From: Paul Cann
Sent: 24 November 2017 15:55
To: Planning.Responses
Subject: RE: Planning Consultation on: M/114/17/HH

Engineers comments in respect to surface water drainage:

APPLICATION **M/114/17/HH**

Description of Works: Single storey rear extension, single storey front/side infill extension with painted render & boarding & removal of entrance porch at front to increase parking area.

General Arrangement Plan ~ As Proposed

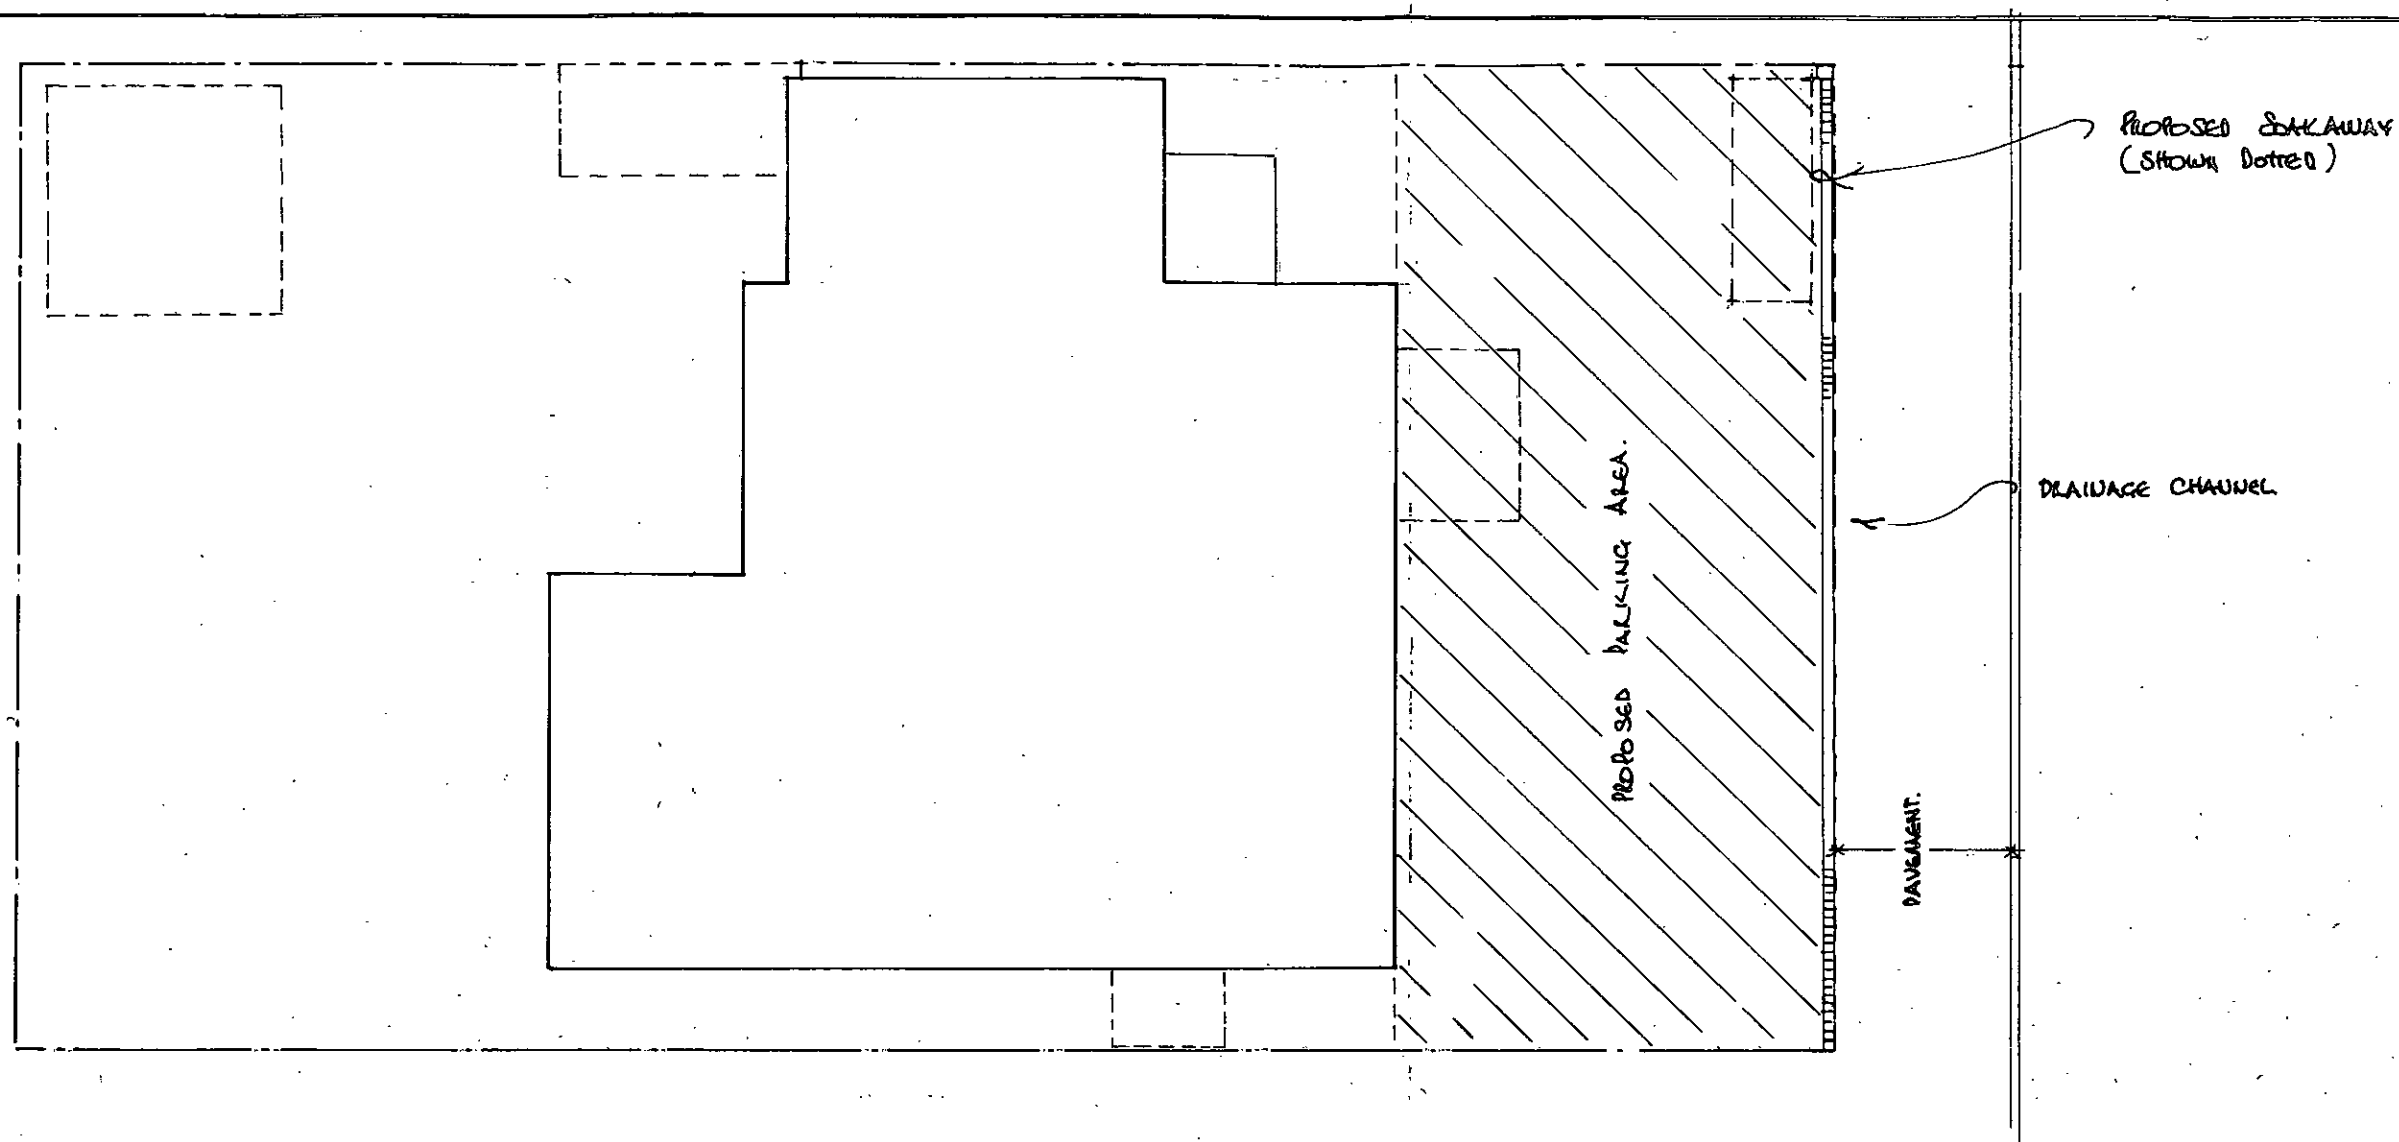
Soakaways must be investigated for surface water disposal. However, there appears to be limited room available on the site, so the applicant is urged to contact us to discuss options.
